Sea Link Energy Cable

Appendix D5 to the Natural England Deadline 5 Submission

Natural England's Additional Comments on Marine Physical Environment

11th March 2026

Plate 2.1 Detail of updated HDD Conceptual Design in Sectional View showing exit position and depth below the eastern edge of the continuous Coralline Crag outcrop.

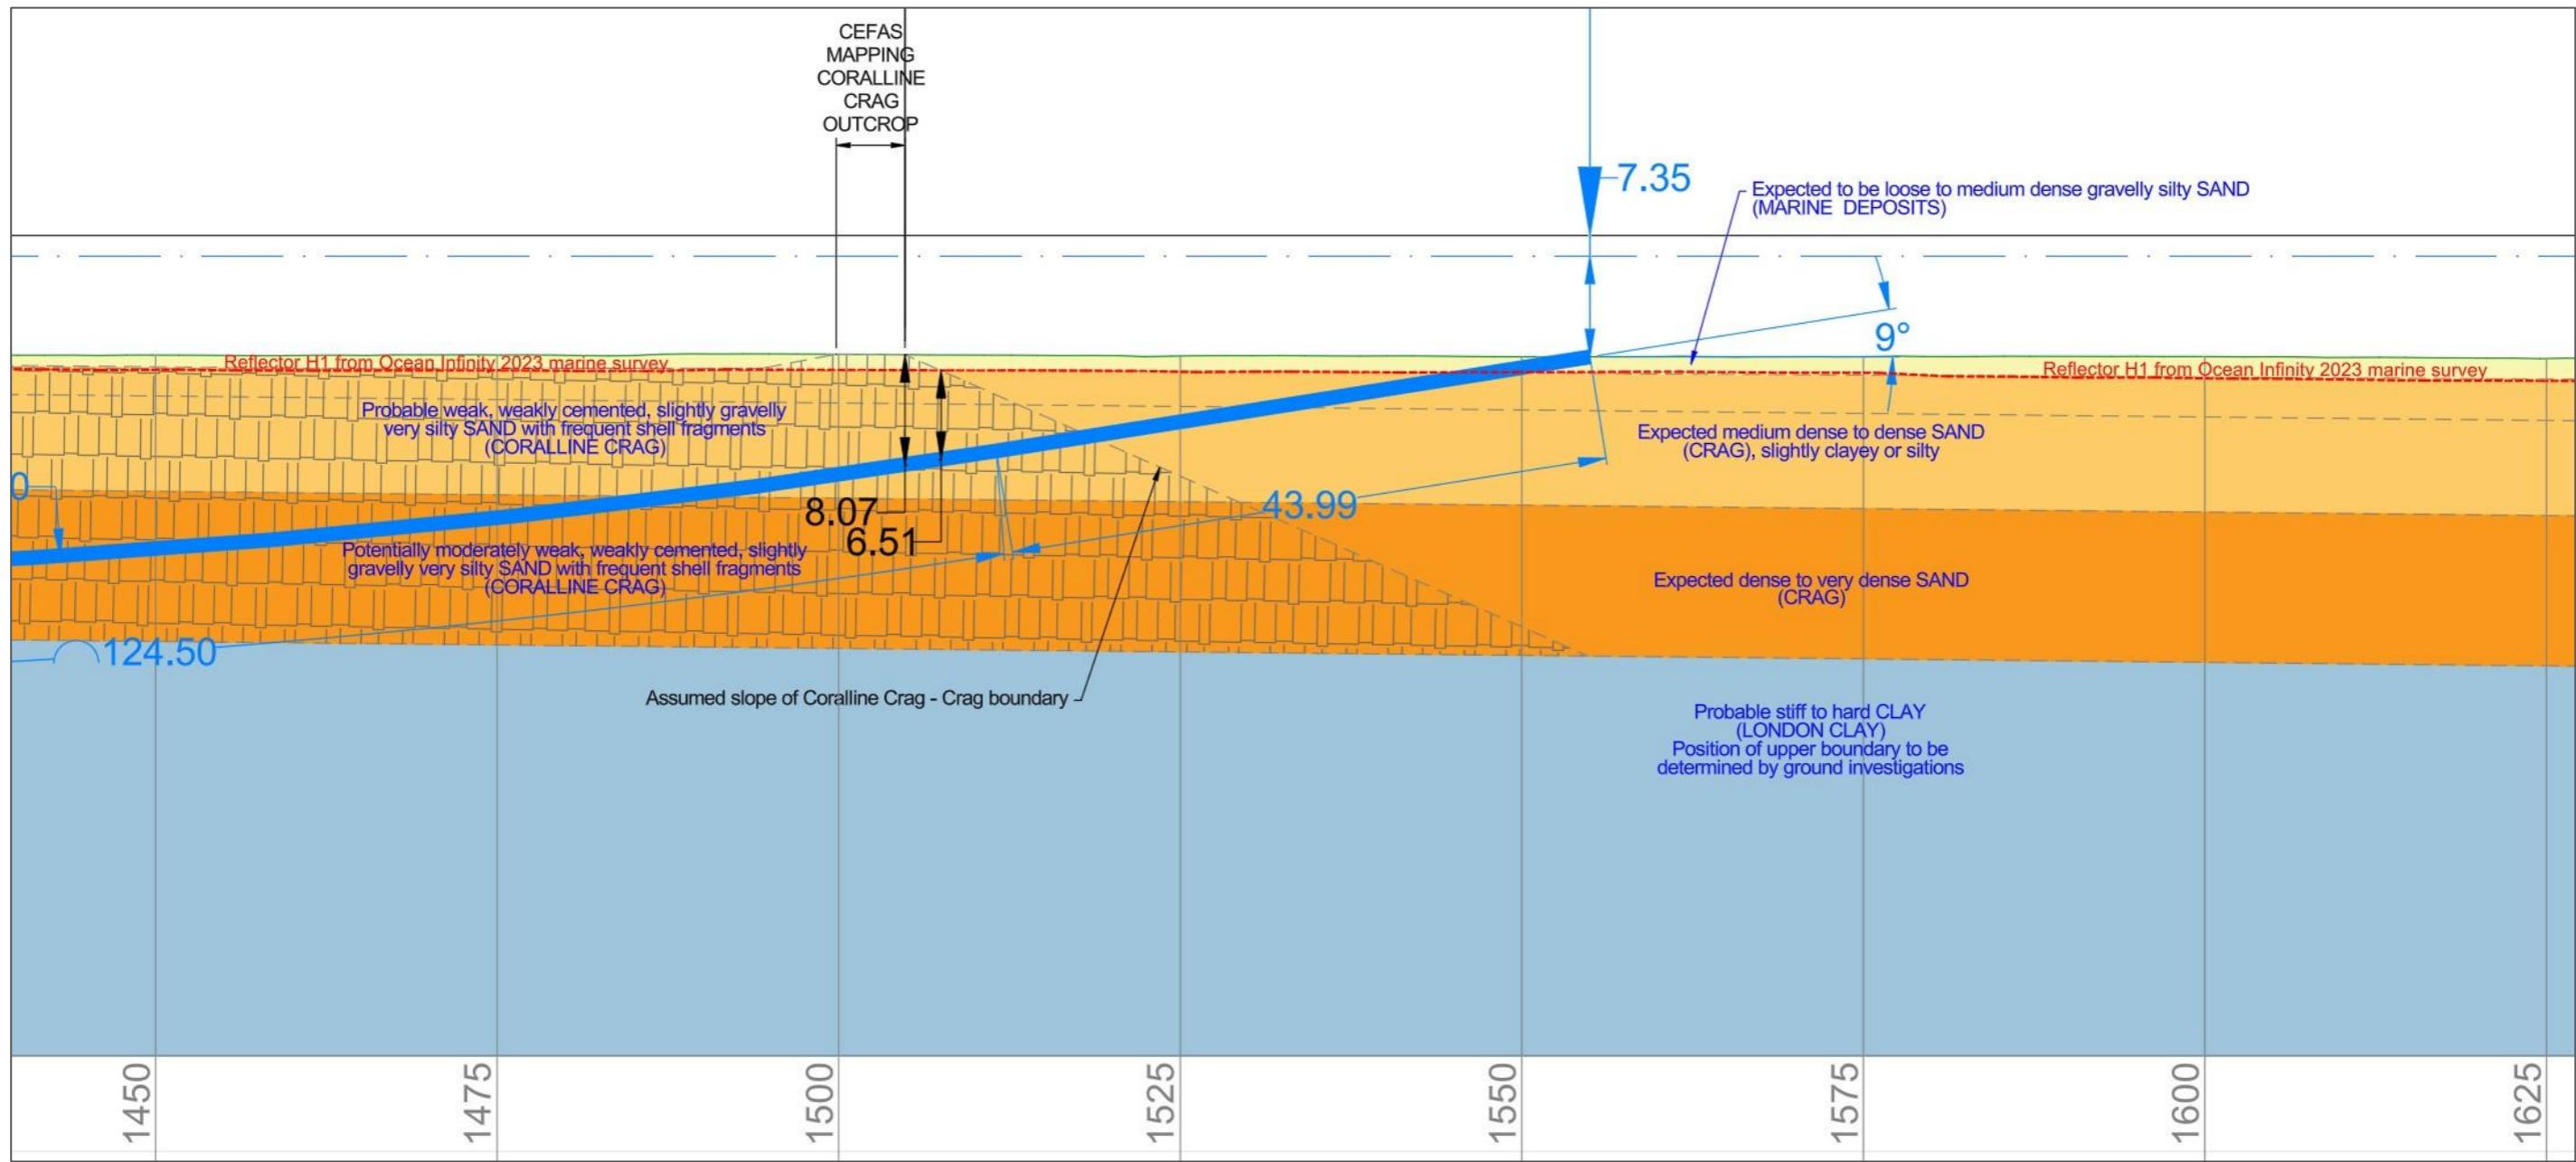
Document reviewed: [REP4-102] 9.113 (A) The Coralline Crag Technical Note			
NE Ref	Section	Key Concern and/or Update	Natural England’s Advice to Resolve Issue
1	2.1.5	Natural England notes the amendment that has been made to commitment GH14 in the REAC to ensure that the lengthened HDDs will exit a minimum of 45m east of the continual Coralline Crag outcrop.	This is welcomed.

2	1.1.3 (& GH14 in REAC)	Natural England notes that the Proposed Project has committed to the HDDs exiting in areas that do not have Coralline Crag outcrop at the surface, as well as exiting east of the continuous coralline crag outcrops defined by Centre for Environment, Fisheries and Aquaculture Science (Cefas) mapping. This is based on Cefas mapping of the Crag. However, the age of the Cefas mapping is not stated. Therefore, we advise that up-to-date mapping may be required to ensure that the extent and location of the Coralline Crag outcrops are identified prior to HDD installation.	We advise that the Applicant should consider whether mapping of the Coralline Crag is needed prior to HDD installation. This will inform understanding of the extent and location of the Crag prior to undertaking HDD installation works.
3	3.1.4	Natural England notes that the Applicant considers that due to the Coralline Crag being 'a weak rock, as exemplified by it forming a resistant outcrop on the sea floor, the HDD bore is expected to be self-supporting in the Coralline Crag and there is not expected to be any localised collapse that could migrate upward to the surface outcrops.' Furthermore, we note in [REP4-082] that the HDD will be designed to ensure that it is within the competent ground beneath the Crag outcrops to ensure that surface outcrops are unaffected by the HDDs. This is also welcomed.	Natural England welcomes the Applicant's efforts to design the HDD at sufficient depth to ensure it is within competent ground beneath the crag outcrops thus avoiding any impacts to the surface outcrops. Whilst the HDD will pass through the Coralline Crag at depth, it is anticipated that this will not lead to collapse of surface outcrops. This resolves our concerns regarding construction impacts on the Coralline Crag.

Plate 5.1 Offshore scheme cable crossings and areas of rock backfill

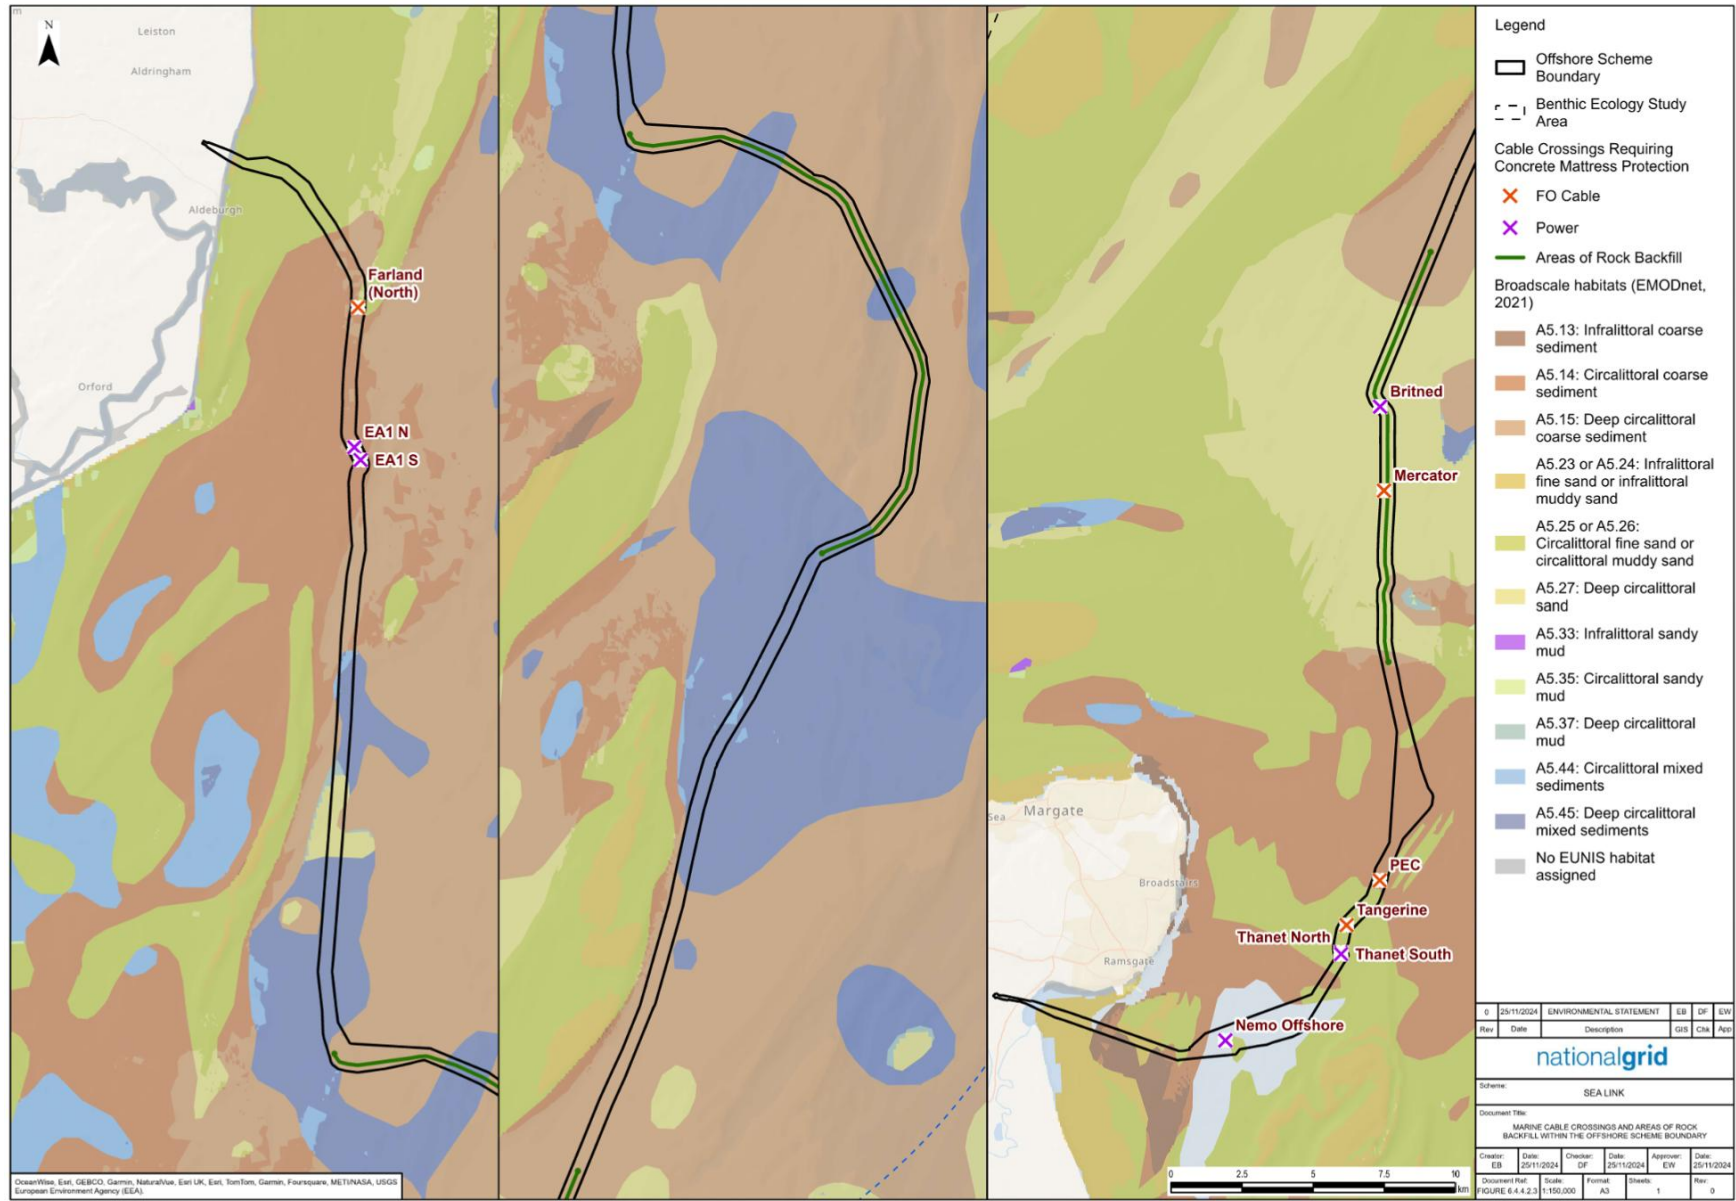
7	1.9.44 & Figure 6.4.4.1.11	<p>Natural England welcomes Figure 6.4.4.1.11 which identifies the location of cable crossings along the offshore scheme route. Although we note it does not identify other sections of the cable route where cable protection may be required.</p> <p>We also note the location of the Farland North crossing directly adjacent to an Annex I sandbank – this appears to be Aldeburgh Napes.</p>	<p>Natural England advises that this impact pathway should be further considered and assessed.</p> <p>We also advise that other potential cable protection locations along the offshore cable route should be identified.</p>
